**QUEST SERVICED APARTMENTS
SITE 22, EDWIN FLACK AVENUE, SYDNEY OLYMPIC PARK
RESPONSE TO SUBMISSIONS**

01 EAST ELEVATION
1:250

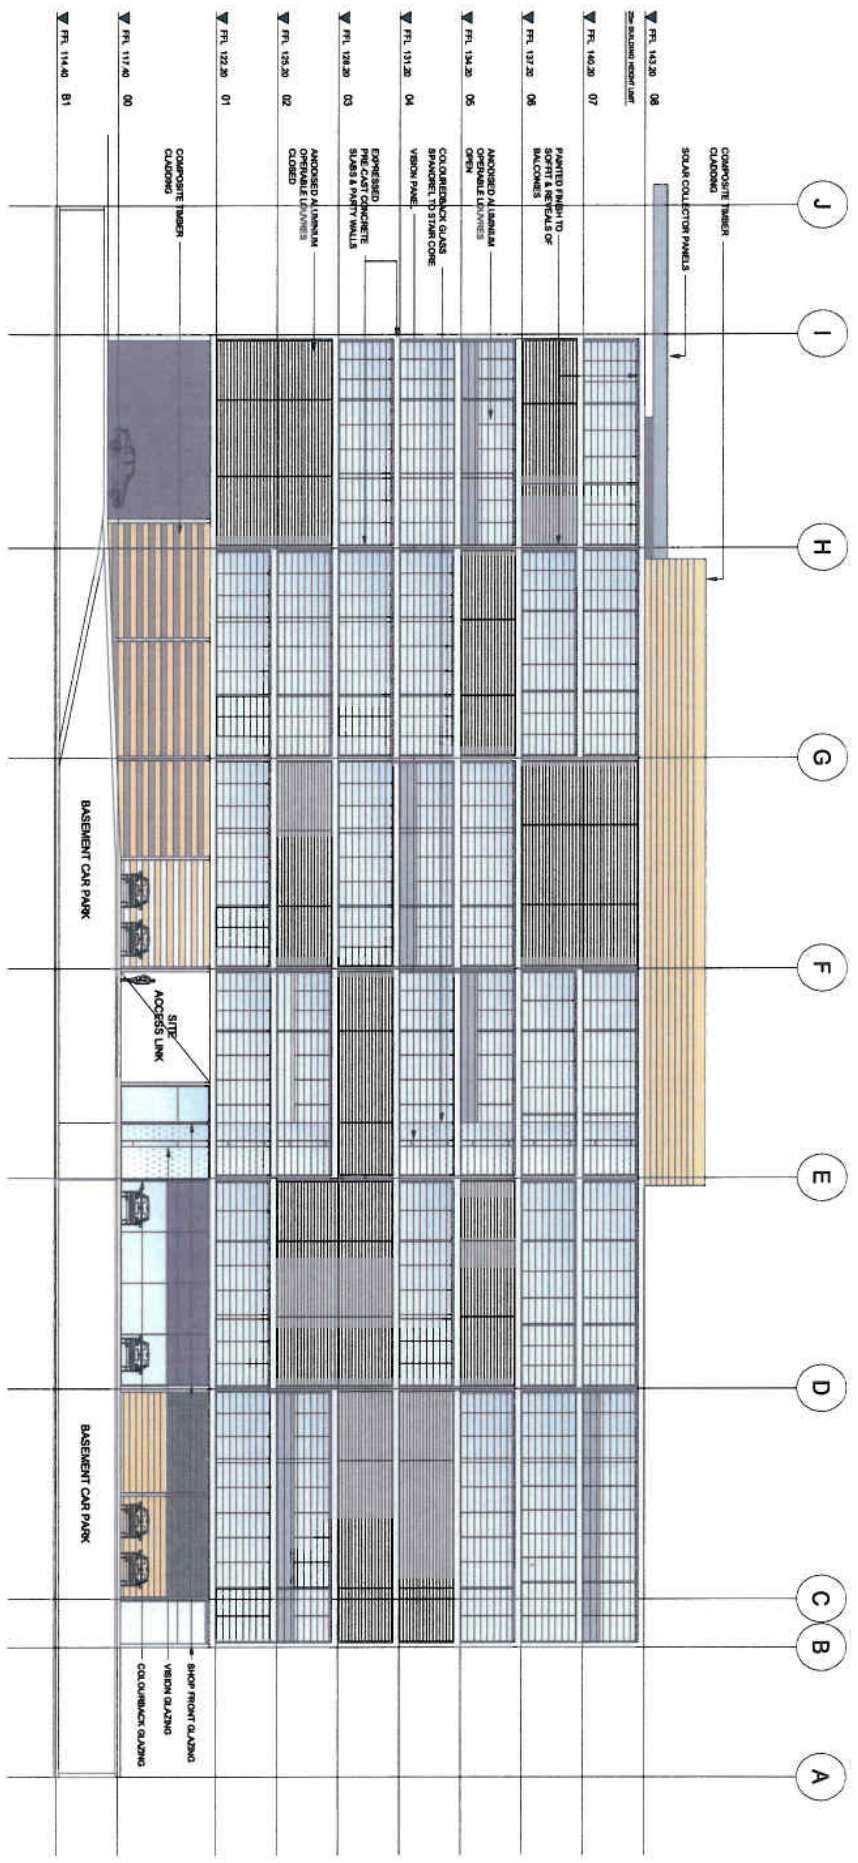
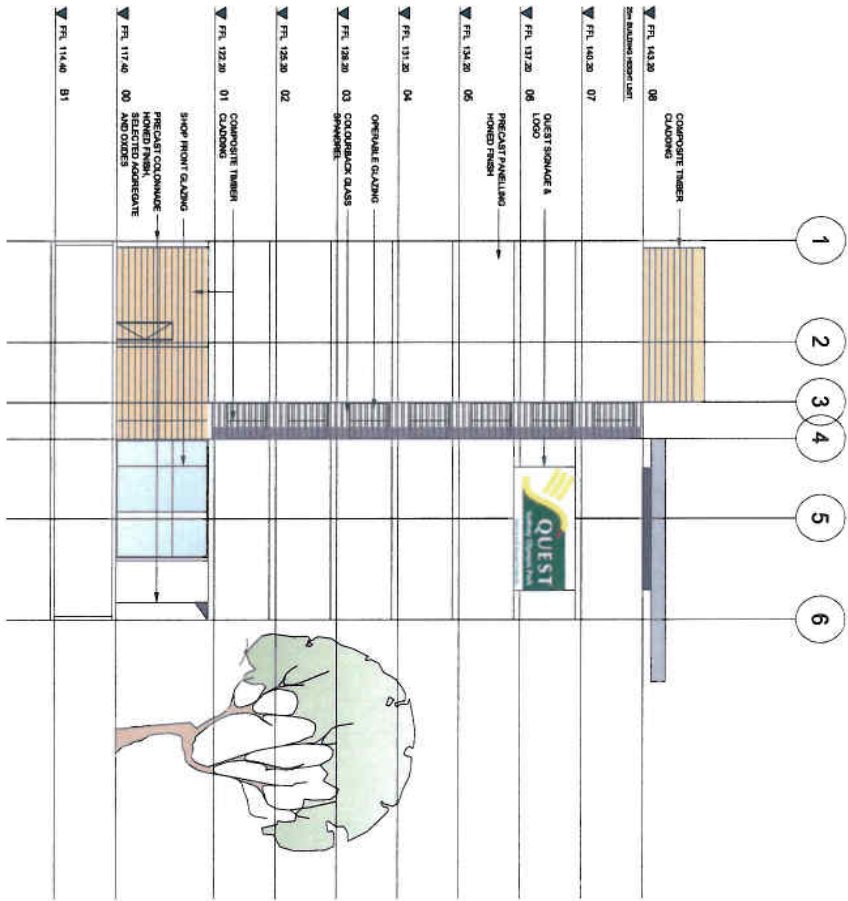
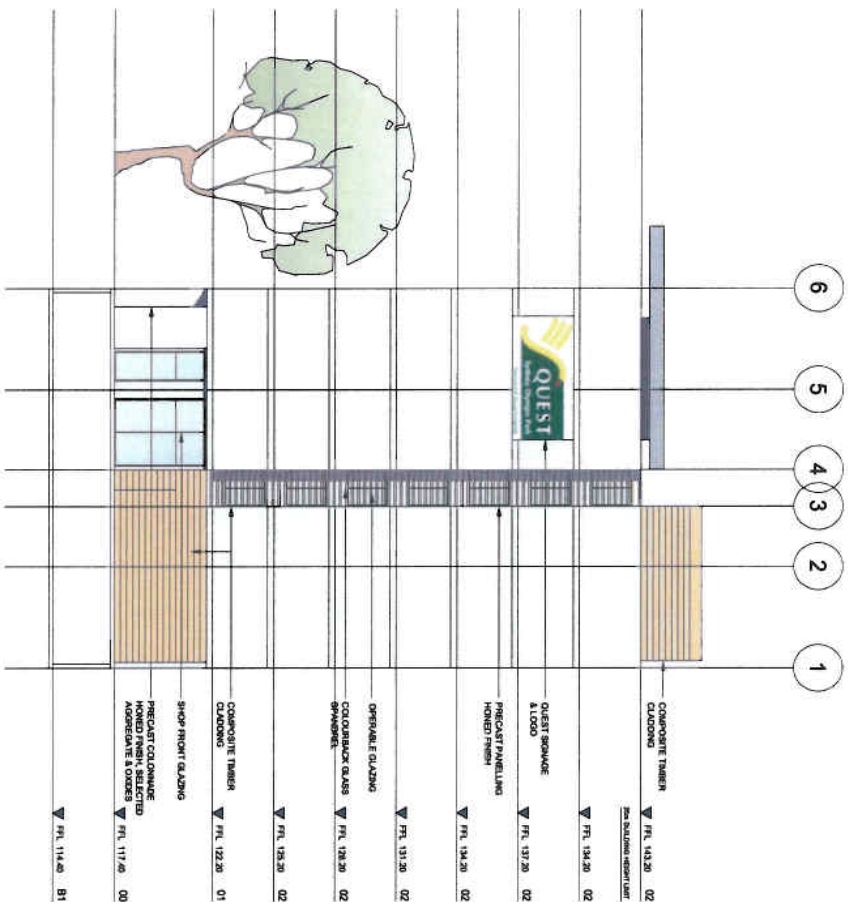
<p>Building Height</p> <ul style="list-style-type: none"> ▪ There is a significant height disparity between the proposed development and the adjacent Formula 1 Hotel. Adjustments to the eastern elevation are required to mitigate this, such as the removal of the top floor balcony (between Gridline G and I) and roof top slab to match the existing parapet height of the Formula 1 Hotel. 	<p>There is a relatively minor height disparity between the Formule 1 Hotel and the proposed development, due to the sloping nature of the site and immediate area (i.e. there is a slight drop in level (i.e. 1.36 m) from the site’s south-west corner to the site’s north-east corner). Removing sections of the top floor balcony and roof top slab, as suggested, will only succeed in achieving an ‘ugly’ building.</p> <p>In terms of height:</p> <ul style="list-style-type: none"> ▪ The proposed development complies with the maximum storey height control set out in the site specific ‘Sydney Olympic Park, Urban Design Guidelines for Site 20, Site 21 and Site 22’ (i.e. 8 storeys). ▪ The proposed development fits in well with the prevailing form, scale and character of existing development within proximity to the site as well as the desired future character of the precinct and future development within the Carter Street Precinct. ▪ The proposed building does not cause any significant environmental impacts to adjoining properties or the public domain in respect of visual impact, view loss, privacy and access to daylight; ▪ The proposed development and in particular the proposed roof feature, will provide visual interest and will enhance the existing skyline, particularly at night. ▪ The proposed development will contribute towards the economic growth of Sydney Olympic Park as well as provide employment opportunities and short term accommodation for visitors to Sydney Olympic Park. <p>No change to the height of the development is required or proposed.</p>

Public domain

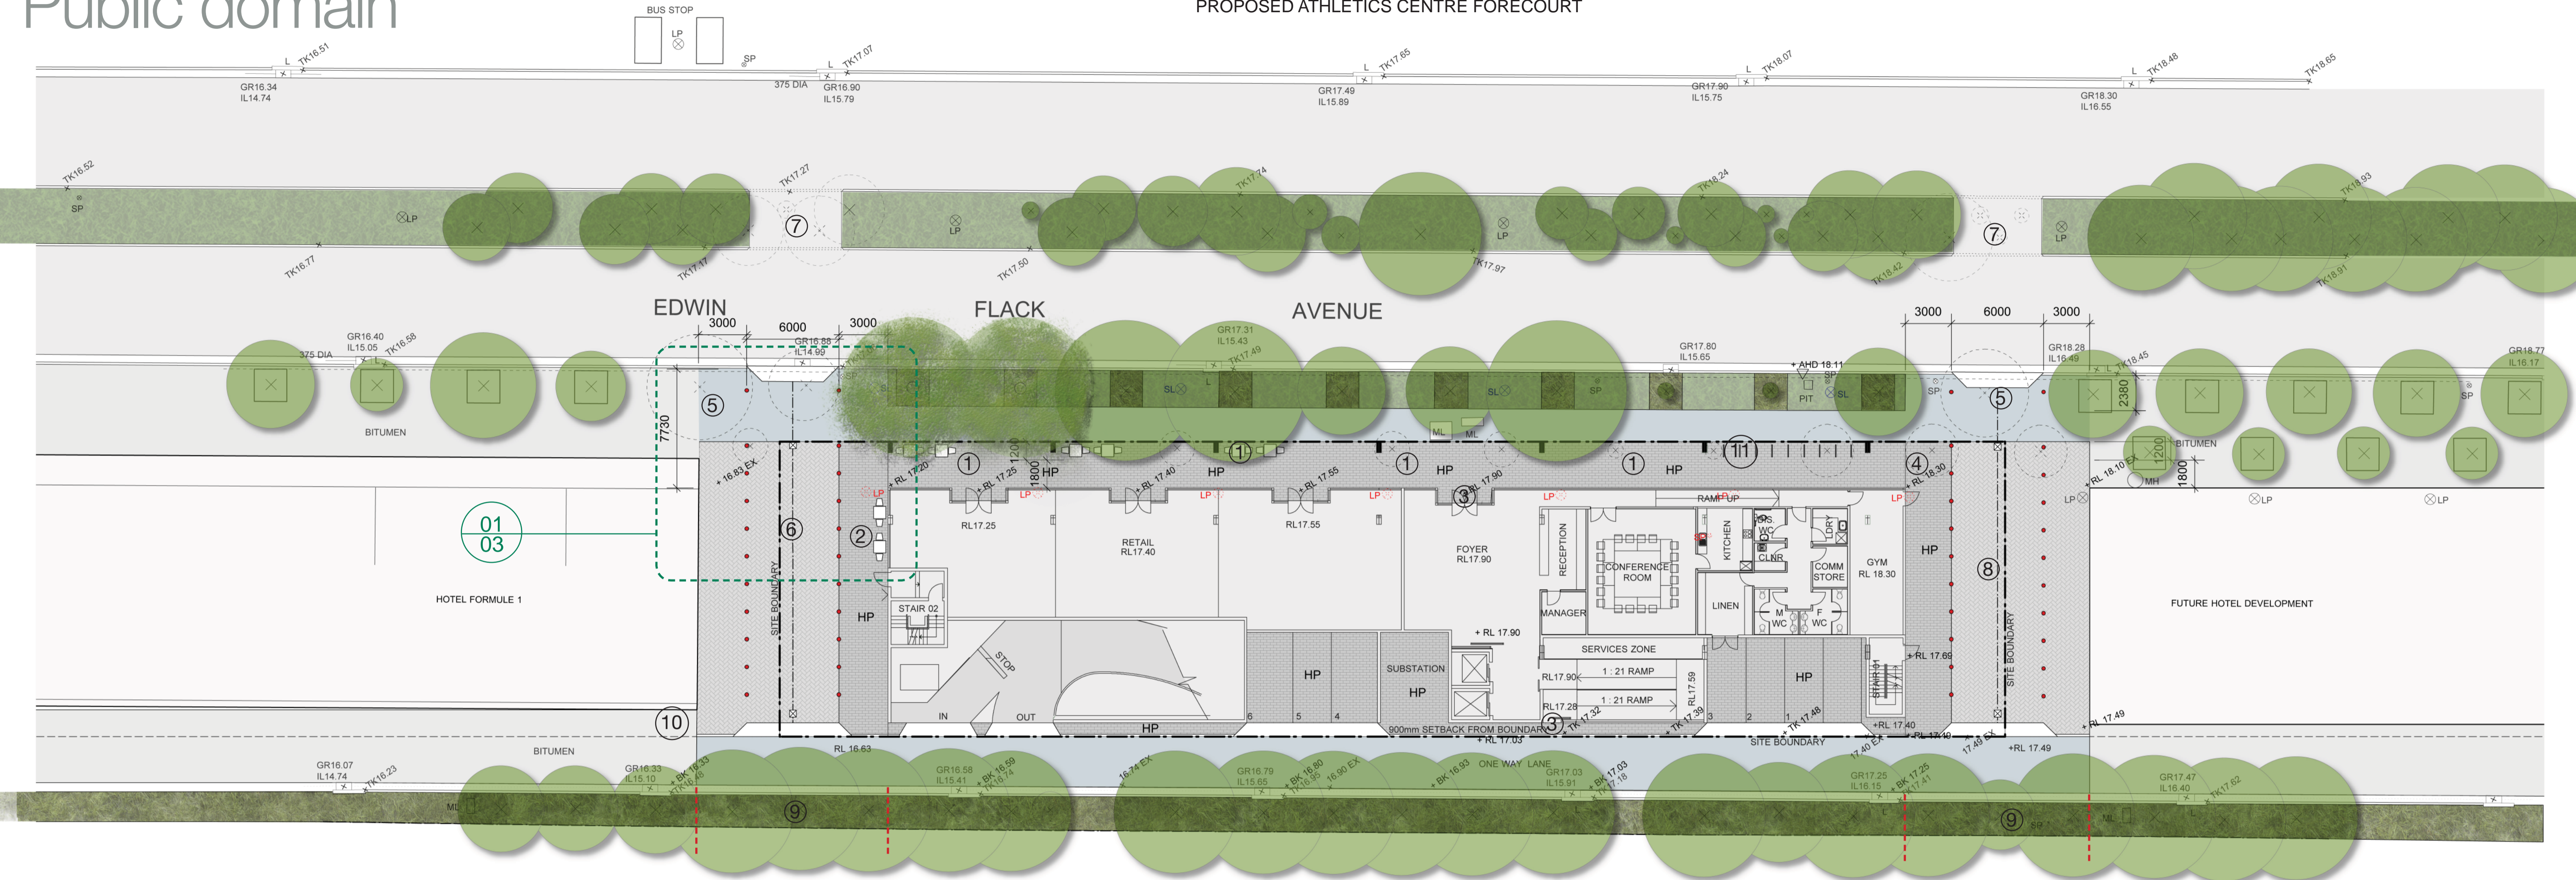
<p>Public Domain and Landscape Design</p> <ul style="list-style-type: none"> ▪ An alternate location for bike racks should be considered as the colonnade is too narrow to accommodate bicycle racks between the columns without affecting pedestrian clearances. 	<p>Noted. Bicycle racks will not be provided within the colonnade. As discussed in Section 3.3 of the EAR, bicycle racks are proposed within the shared access way between the proposed development and the Formule 1 Hotel (to the south-west of the proposed building).</p>
	<p>2.3 Operational</p>	
	<p>The one-way directional system of the service lane is supported, with entry to the lane off Uhrig Road. However, during normal day to day operations, the exit from the service lane should be left turn only into Birnie Ave (not right as suggested), or alternatively via the shared ways into Edwin Flack Ave (left out only).</p>	<p>Noted. Quest invites the imposition of a condition of consent to this affect.</p>

PROPOSED SUBDIVISION OF LOT 16 IN DP1110035
 EDWIN FLACK AVENUE, SYDNEY OLYMPIC PARK
 CLIENT: QSA BUSINESSES PTY LTD

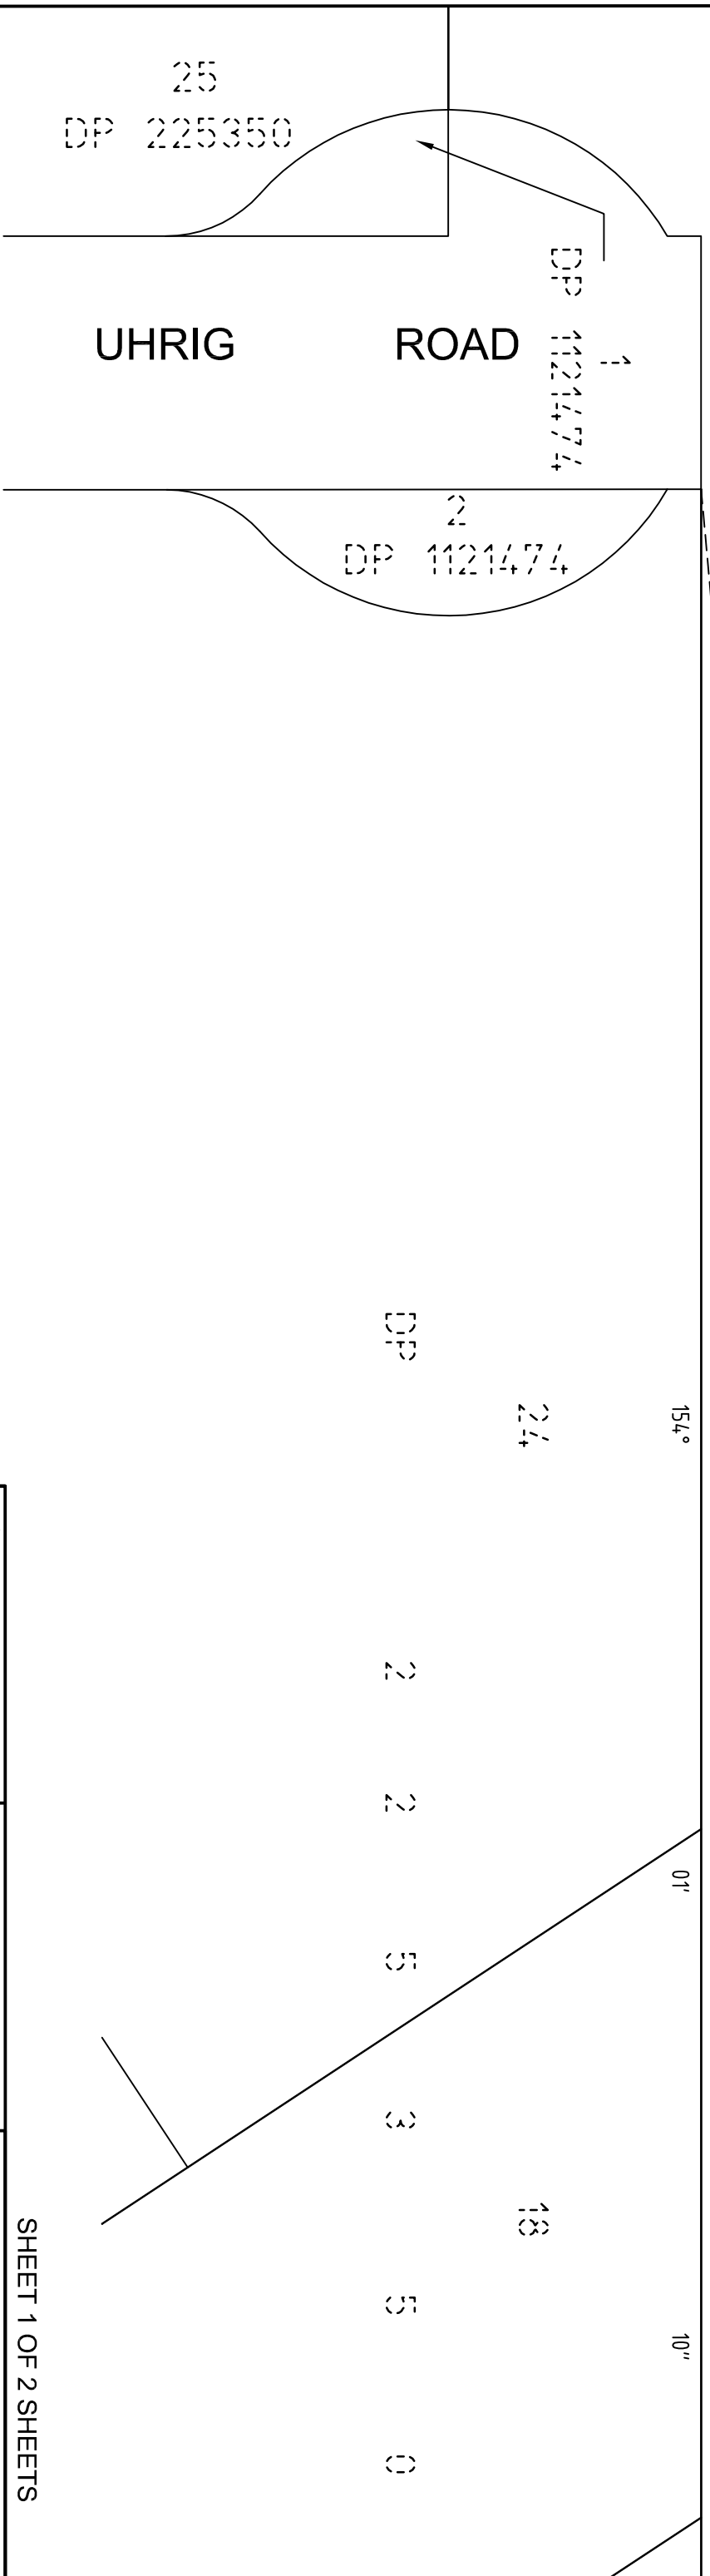
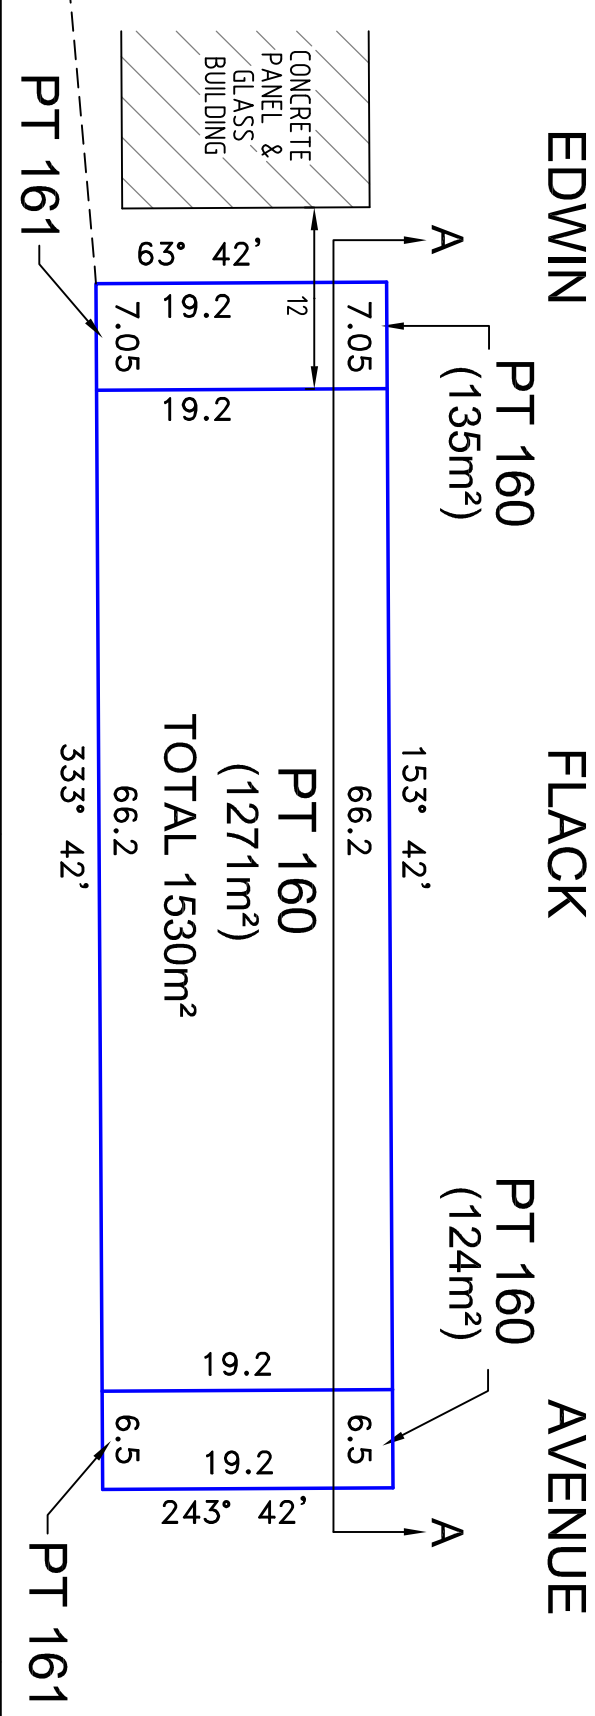
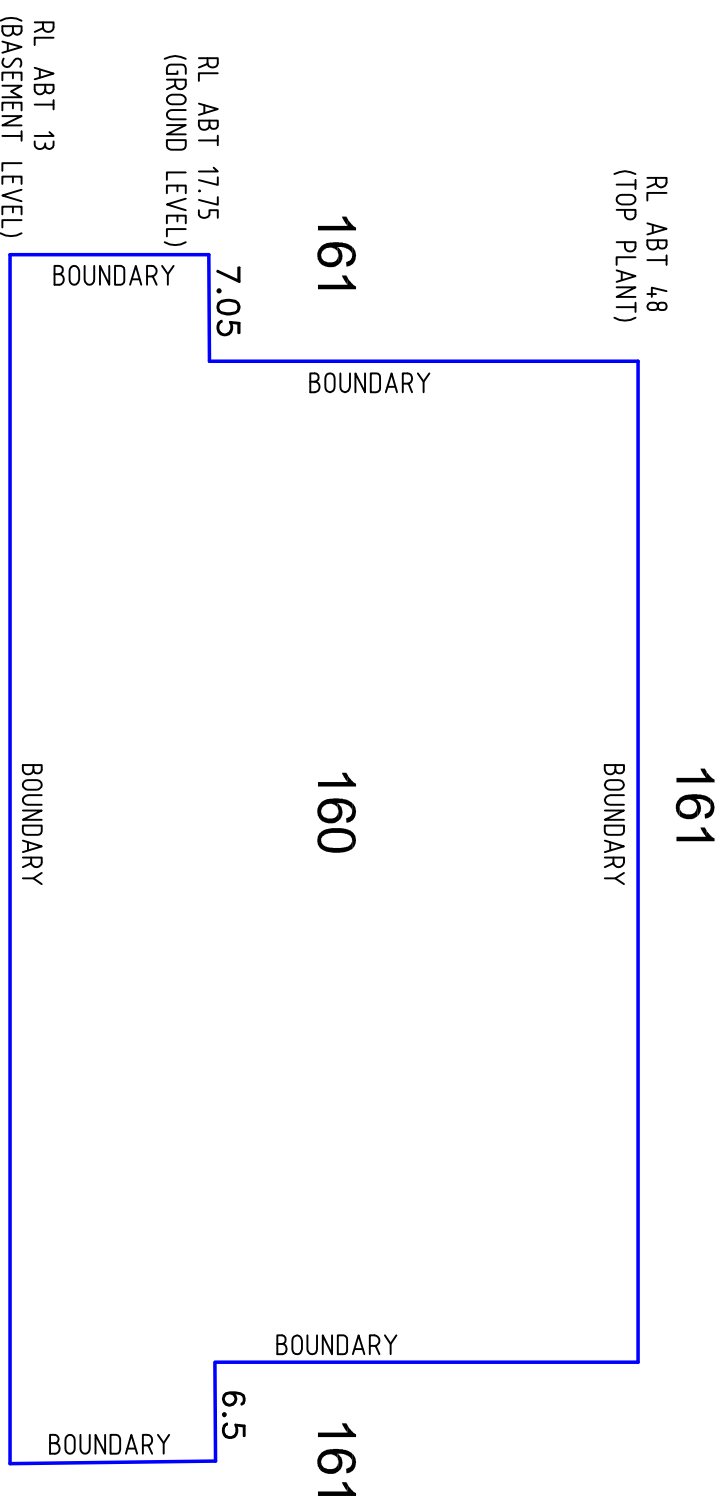
<p>2.2 Design</p> <p>Building location and set out:</p>	
	<ul style="list-style-type: none"> Site survey, subdivision and location plans all show discrepancies in alignment with the adjacent Formula 1 Hotel frontage - the Edwin Flack Ave frontages of both buildings should align at the outside face of the colonnade as well as the face of the shopfronts 	The Edwin Flack Avenue frontages of the proposed development and the adjoining Formule 1 Hotel align at the shopfronts (refer to Architectural Drawing O1 dated 17 November 2009 (Attachment E)). The width of the proposed colonnade is 3 m, as required by the SOPA Design Review Panel.
	<ul style="list-style-type: none"> The Architect's Context street elevations and the Landscape Concept design both show incorrect widths for the shared ways at either end of the proposed building - both should be 12m wide. 	As shown on the Architectural Drawings (refer to Appendix D of the EAR and revised Architectural Drawing O1 dated 17 November 2009 included at Attachment E), a 12 m wide shared away is provided for at the northern and southern ends of the proposed building.
